From: Samantha Allen
Sent: 16 August 2018 10:07:04
To: Planning Scanning
Cc:
Subject: FW: M/83/18/HH - Holly Cottage, Yapton
Attachments: OS site plan highways visibility splays.pdf

Comments as requested addressing the WSCC highway comments raised regarding the above planning application, dated 01/08/18.

Holly Cottage, Yapton Road, Middleton-on-sea, Bognor Regis

DRAWING
**SITE PLAN
LOCATION PLAN**
DRAWING No
264/01

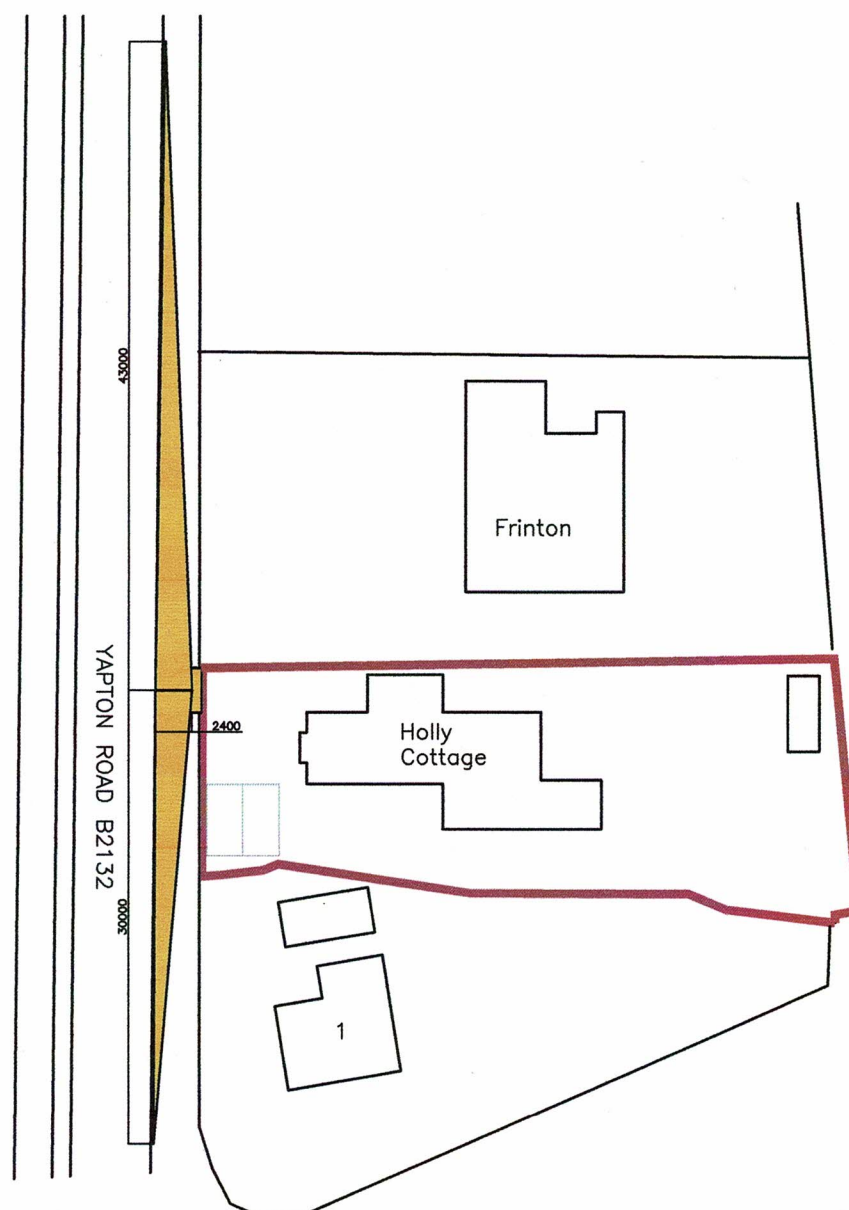
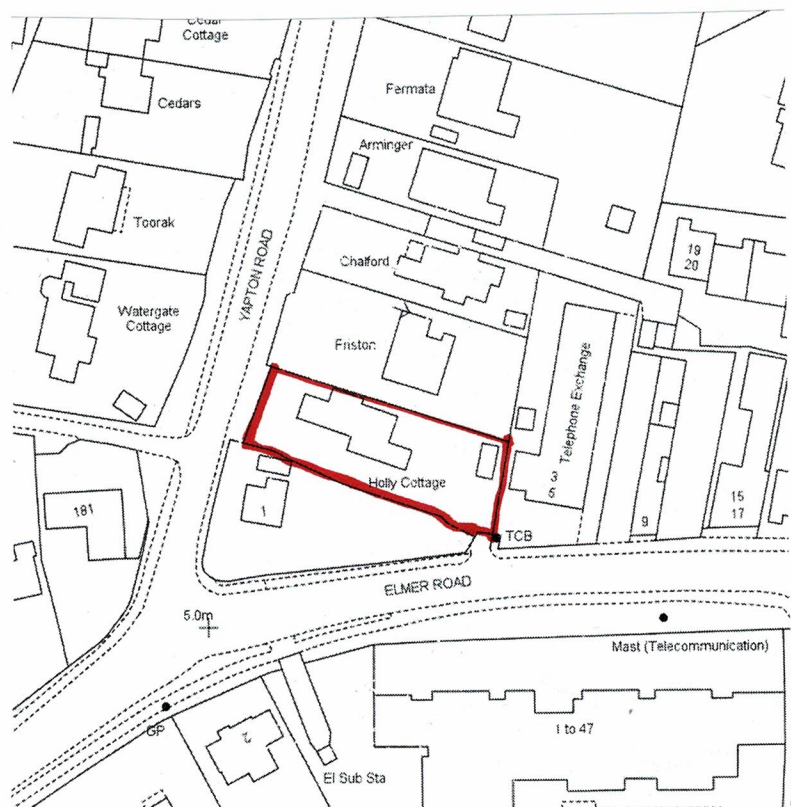
The provision of the vehicular access off Yapton Road will provide parking adjacent to the property's front door, significantly reducing the current walking/carrying distances in comparison with the proposed access arrangements.

The reflective highway posts positioned within the eastern verge of Yapton Road currently prevent/discourage on street parking in the vicinity of Holly Cottage. The proposed secondary access would not result in a loss of on street parking provision for neighbouring residents, as the existing highway layout and street furniture currently effectively prevent/discourage on street parking where the proposed access would be located.

Holly Cottage, Yapton Road, Middleton-on-sea, Bognor Regis

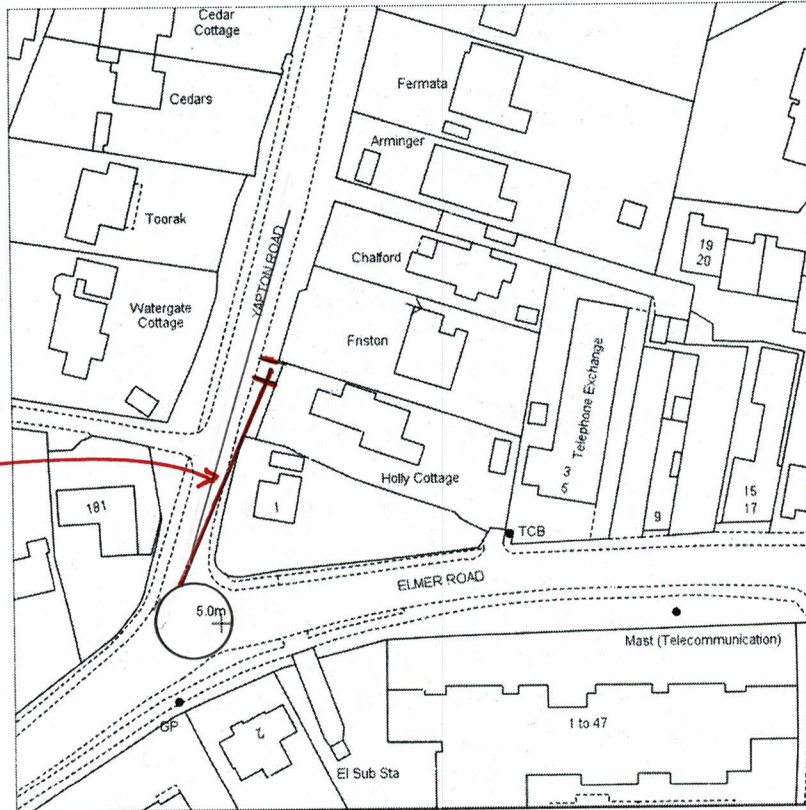
We note that WSCC are seeking a junction visibility splay of 2.4 x 43m in line with MfS for a highway with a speed limit of 30mph, and that they are content that the northern junction visibility splay can be achieved within the existing highway boundary.

We would highlight that MfS2 permits the 'y' distance to be measured to the middle of the road (ie highway centreline) for the left hand visibility splay, if it is *'unlikely that vehicles approaching from the left on the main arm will cross the centreline of the main arm.'* It is our view that vehicles that have entered Yapton Road from either Elmer Road or Middleton Road have just negotiated a mini roundabout junction and thus will be within their designated lane, and thus deemed unlikely to cross the centreline of the main arm in this location. Furthermore, the vehicle speeds travelling north along Yapton Road from the mini roundabout are likely to be lower than 30mph immediately north of the junction, given the tight turning manoeuvres required to negotiate the mini roundabout junction.

On this basis it is considered that a junction visibility splay to the south of the new vehicular access to Holly Cottage should be measured to the centreline of Yapton Road. However, it is considered that 43m would take the visibility past the roundabout junction, and thus the splay should be taken to Yapton Road's centreline intersection with the outer diameter of the roundabout, resulting in a 'y' dim of approx. 36-40m. It is considered that this junction visibility is clearly achievable from site inspections, and trust that your WSCC mapping concurs with this view.

It is acknowledged that highway verge along the eastern side of Yapton Road tapers in from Holly Cottage to the south towards Elmer Road. However, the proposed visibility splay outlined above is not affected by this occurrence. However, existing vegetation between Holly Cottage and Elmer Road along the eastern verge appears to have grown in recent years and this could be addressed to the satisfaction of the Highway Inspector through a planning condition should you be minded to concur with our above views, in order to improve/maintain highway safety.

Please see below comments made by my Highways Consultant addressing the comments from WSCC.
I also attach a site plan demonstrating that the visibility splay can be achieved.
